M3 Junction 9 Improvement

Scheme Number: TR010055

8.22 Applicant Response to the Examining Authority's Third Written Questions (ExQ3)

27 October 2023

Drawing Number: HE551511-VFK-LLO-M3SB\_XX-DR-ZL-40003

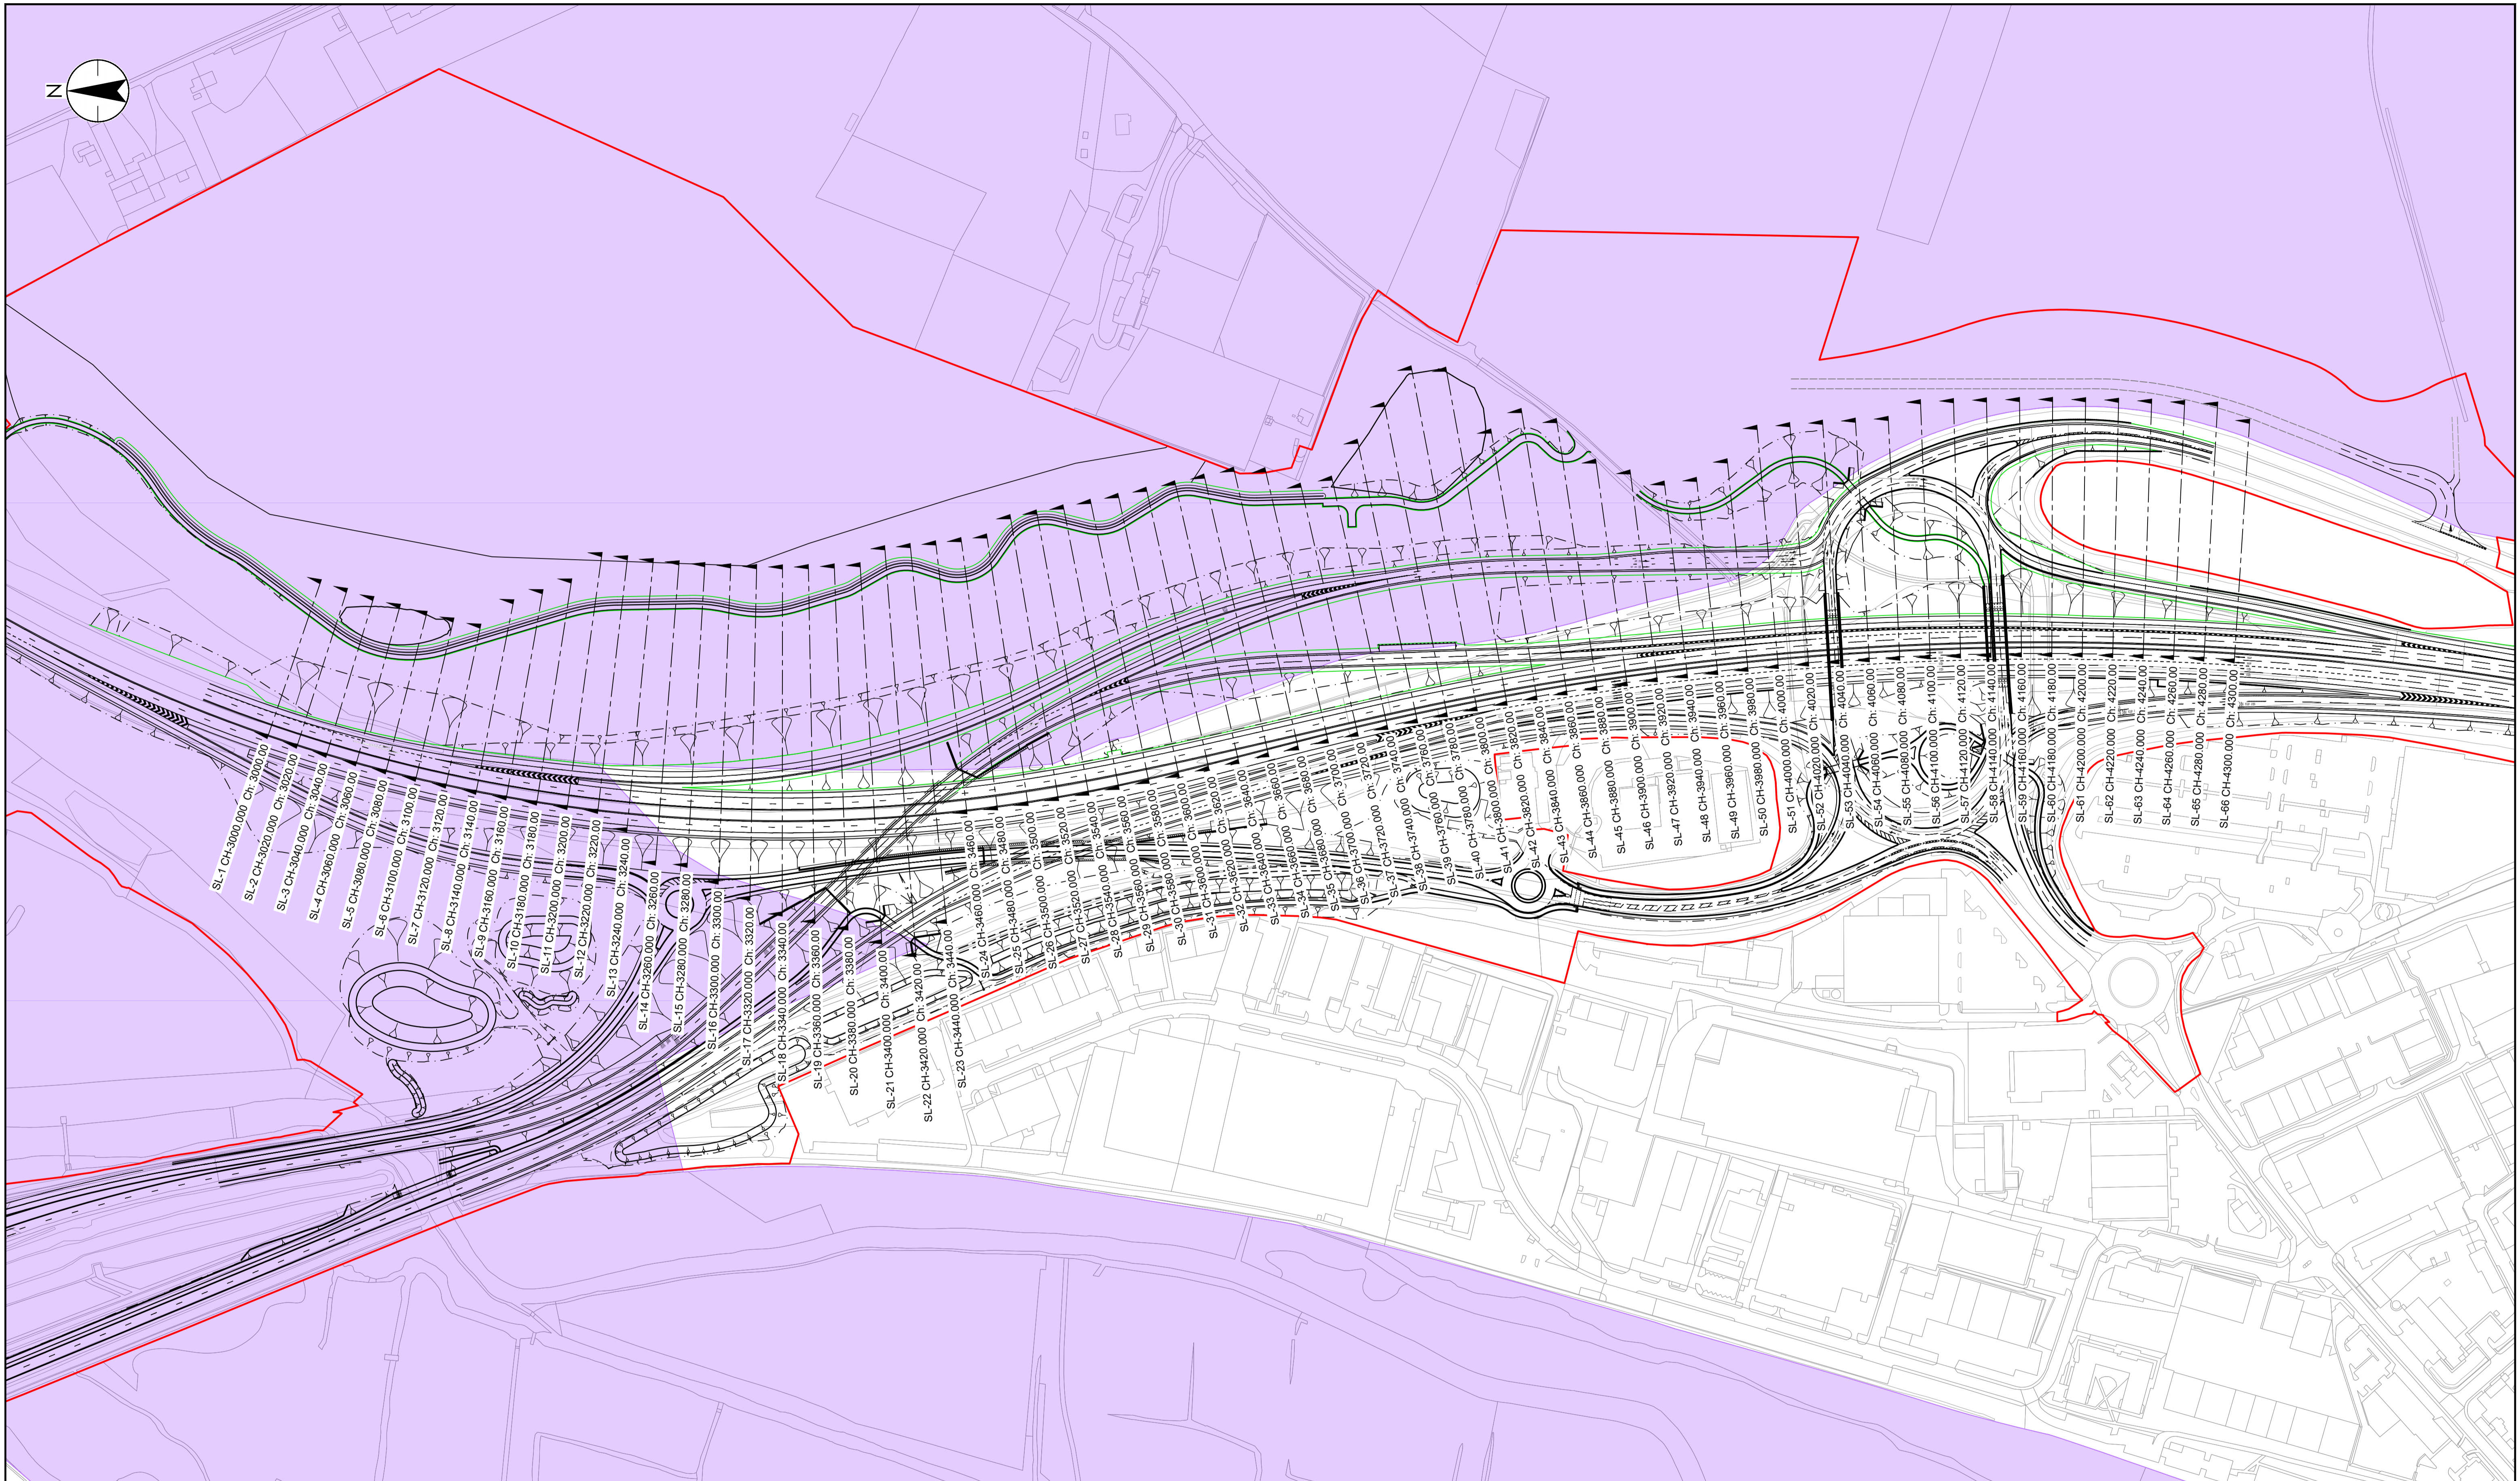
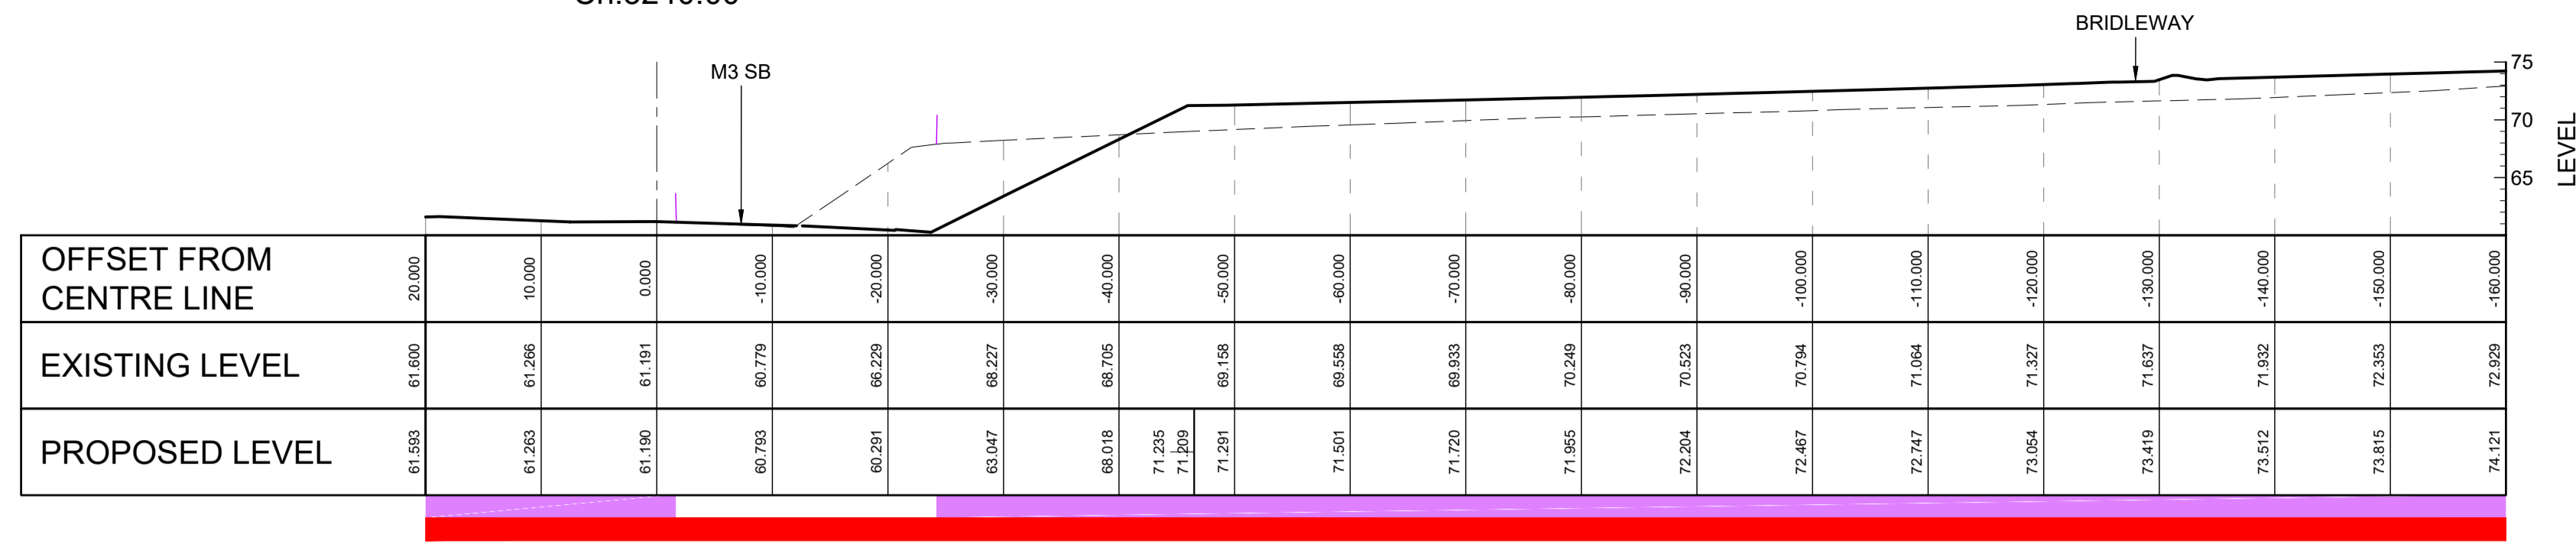
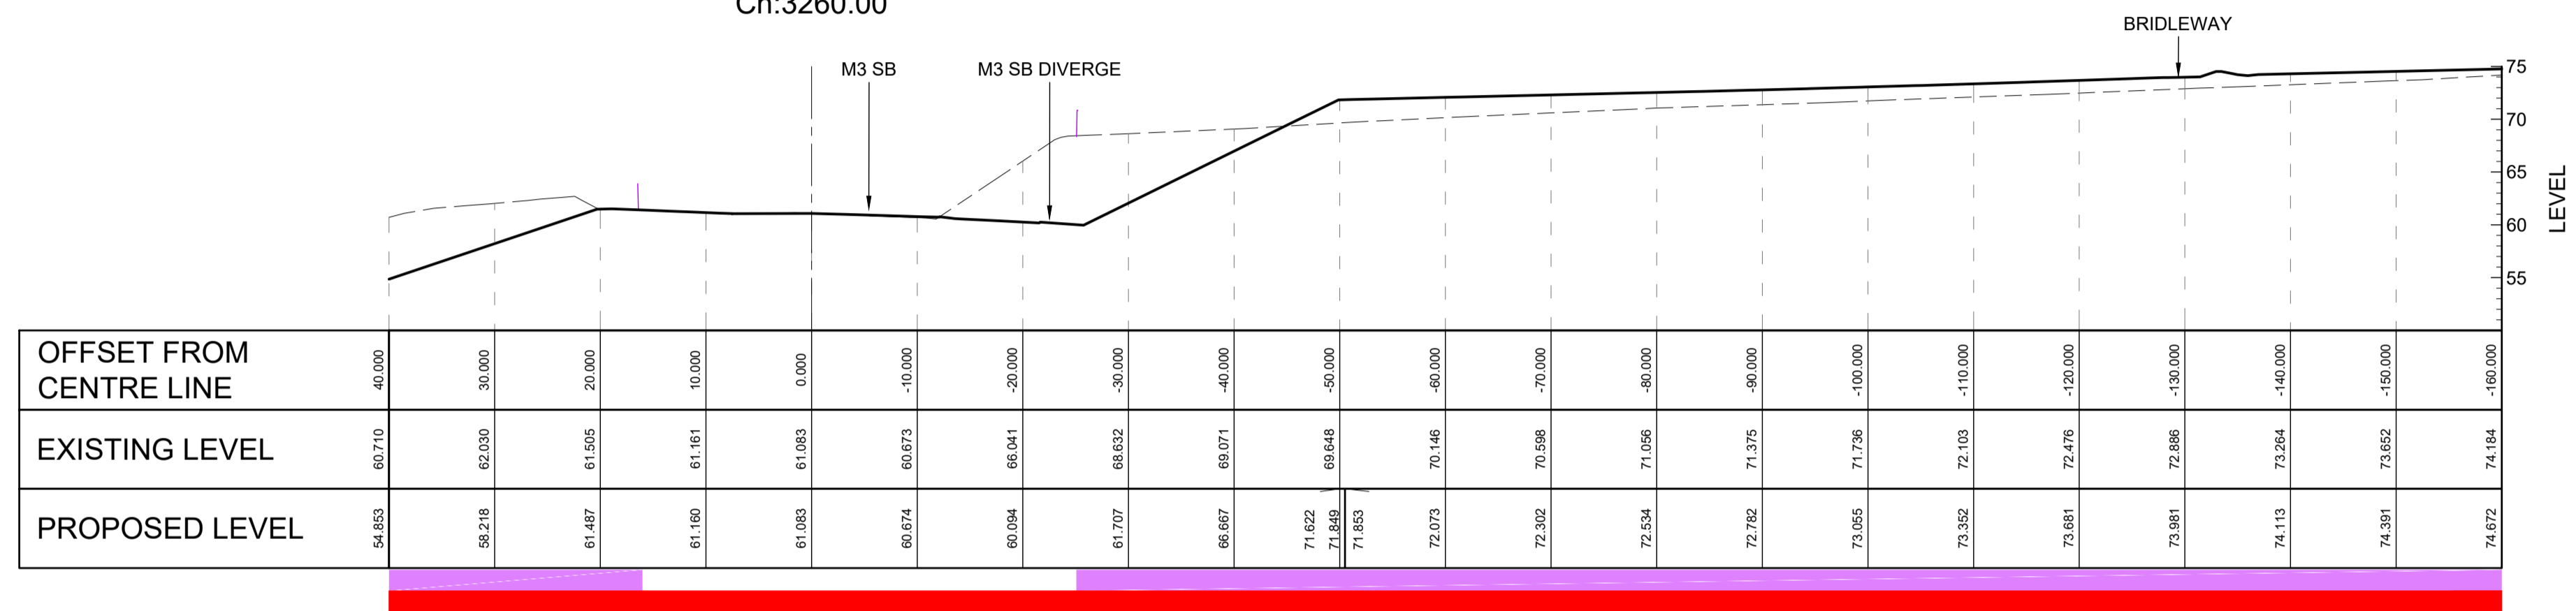
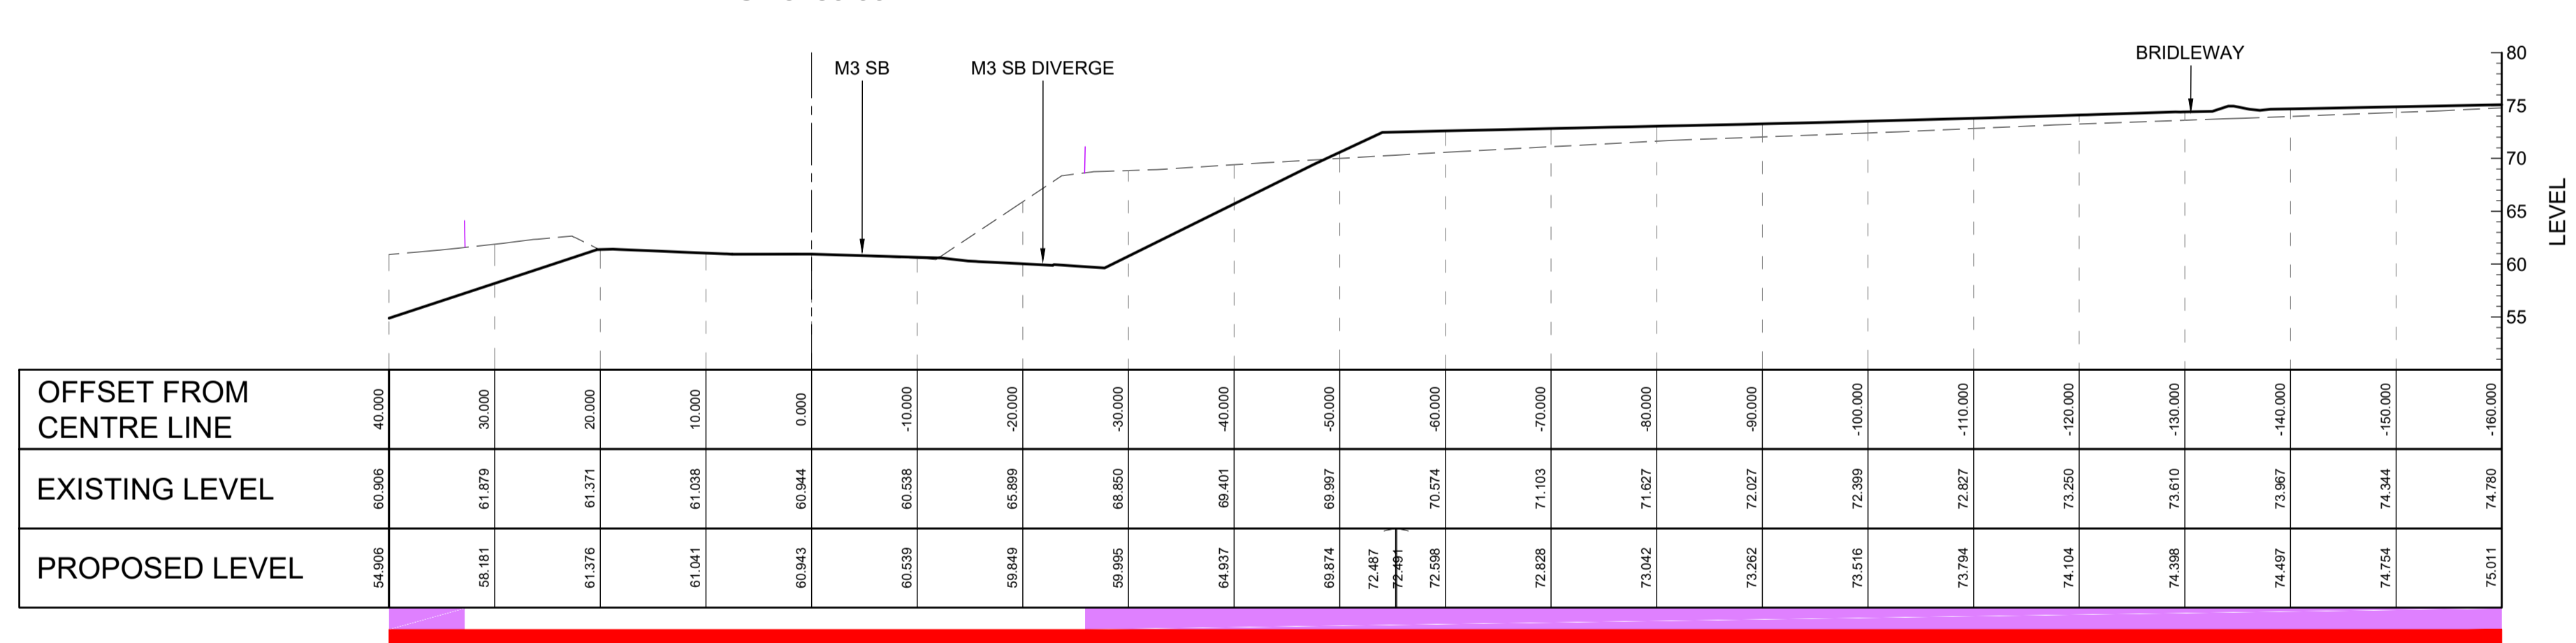
ExQ3	Question to:	Question
Q1.3.1	General The Applicant	In ExQ 1.2.3 [PD-011] the ExA requested detailed engineering cross sections at 20m intervals along string CH-HML-E_M3SB between chainages 3000 and 4300. The cross sections were provided by the Applicant [REP5-003] however they omitted distance and level data as would be anticipated in detailed engineering sections. Please provide an update to the cross sections submitted at deadline 5 to include distance and level data in rows below the drawn sections.
Applicant Response		
Please refer to Engineering Sections at 20m Intervals - ExA WQ2 1.2.3 (2.15, Rev 1) submitted at Deadline 6.
